CITY OF PORTLAND

Re: 13 GRANT ST
CBL: 036- - D-016-001-01
DU: 9

HOUSING INSPECTION REPORT

Location: 13 GRANT ST

GRANT ST.
APARTMENT 5

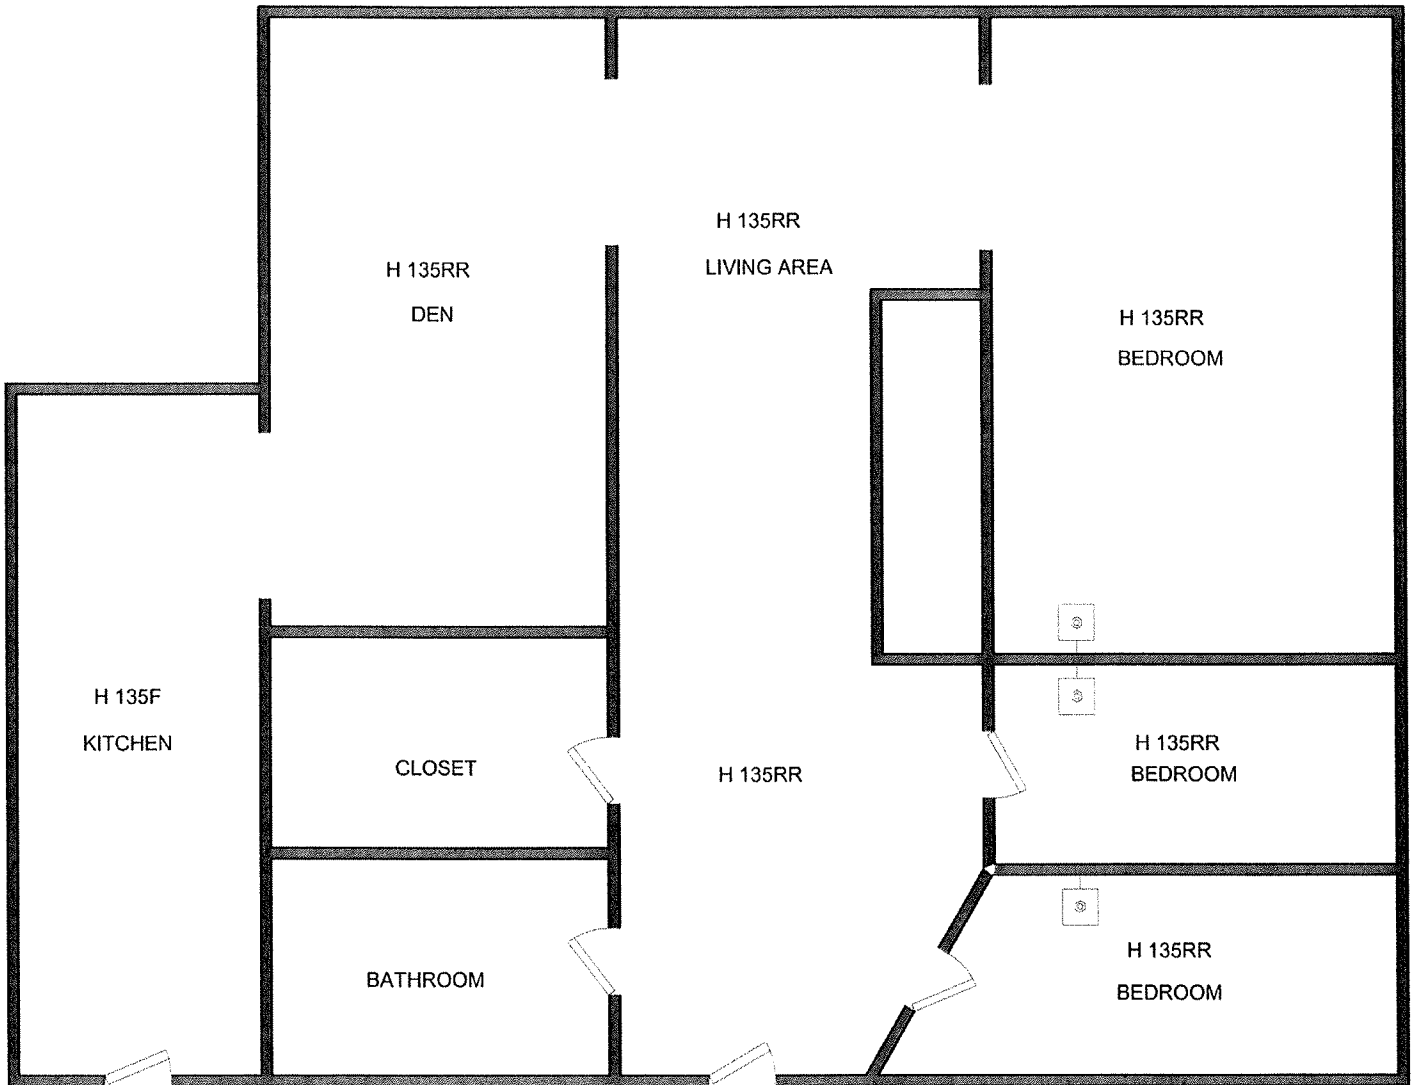
| 10. INT - 3RD FL - APT #5 - BATHROOM
| 11. INT - 3RD FL - APT #5 -
| 12. INT - 3RD FL - APT #5 - BATHROOM
| 13. INT - 3RD FL - APT #5 - BATHROOM
| 14. EXT - 3RD FL - APT #5 - ALL ROOMS
| 15. INT - 3RD FL - APT #5 - BEDROOMS
| 16. INT - 3RD FL - APT #5 - BEDROOM LIGHT SWITCH

2ND FLOOR COMMON AREAS &  
APTS. 3 & 4

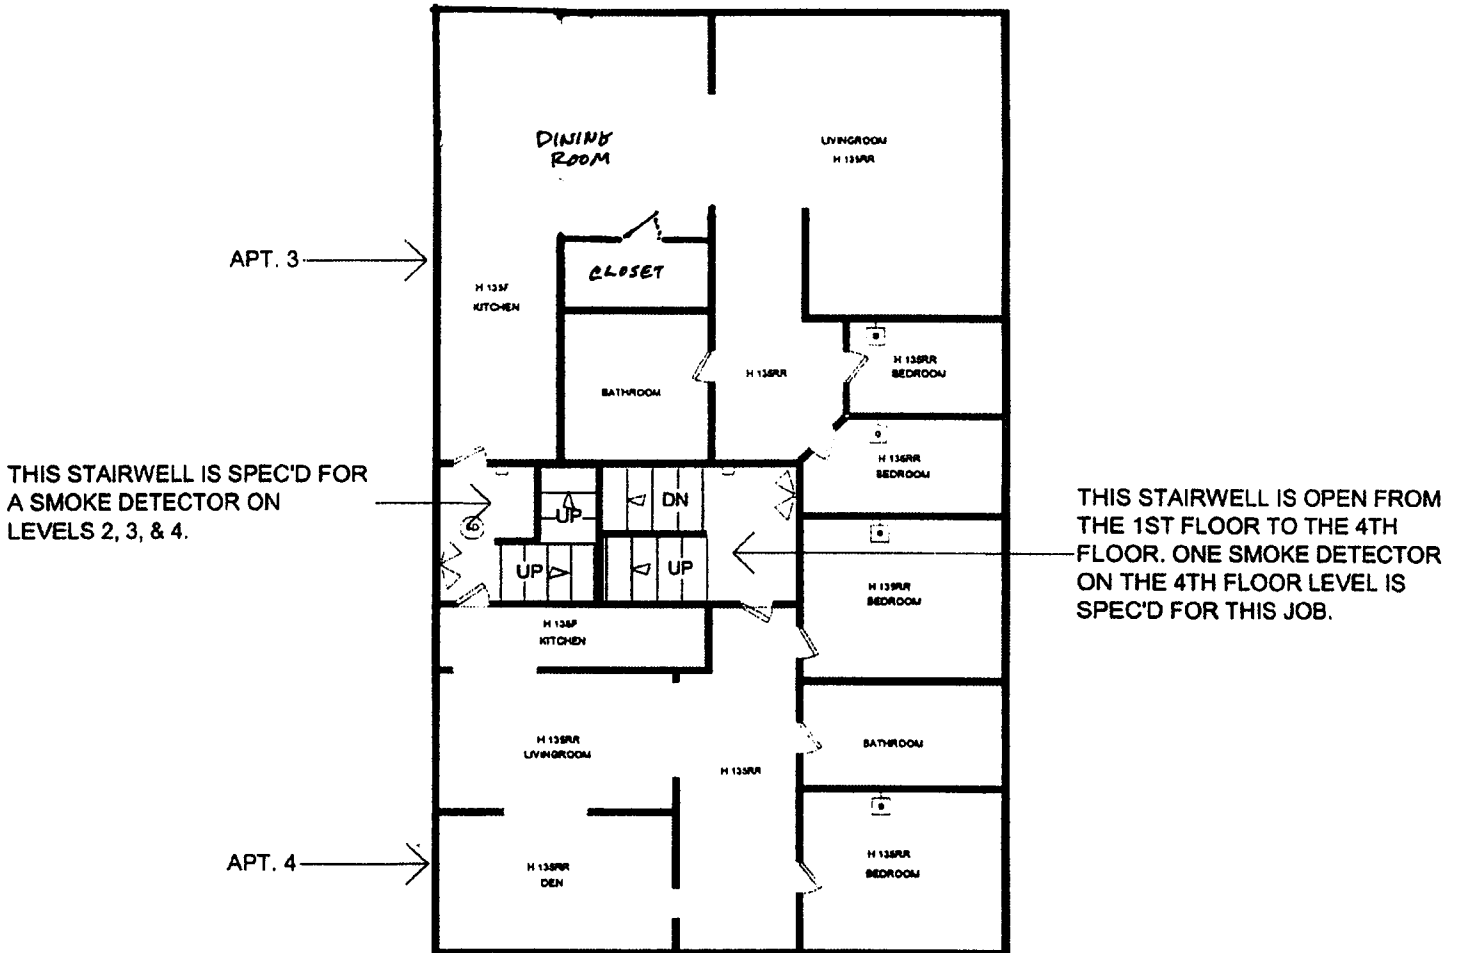
| 1. INT - 2ND FL - APT #4 - KITCHEN
| 2. EXT - 2ND FL - APT #4 - ALL ROOMS
| 3. EXT - 2ND FL - APT #4 - BEDROOM
| 4. INT - 2ND FL - APT #4 - HALL
| 5. INT - 2ND FL - APT #3 - BATHROOM
| 6. INT - 2ND FL - APT #3 - HALL
| 7. EXT - 2ND FL - APT #3 - ALL ROOM
| 8. INT - 2ND FL - APT #3 - BEDROOM/LIVING ROOM
| 9. INT - 2ND FL - APT #3 - KITCHEN
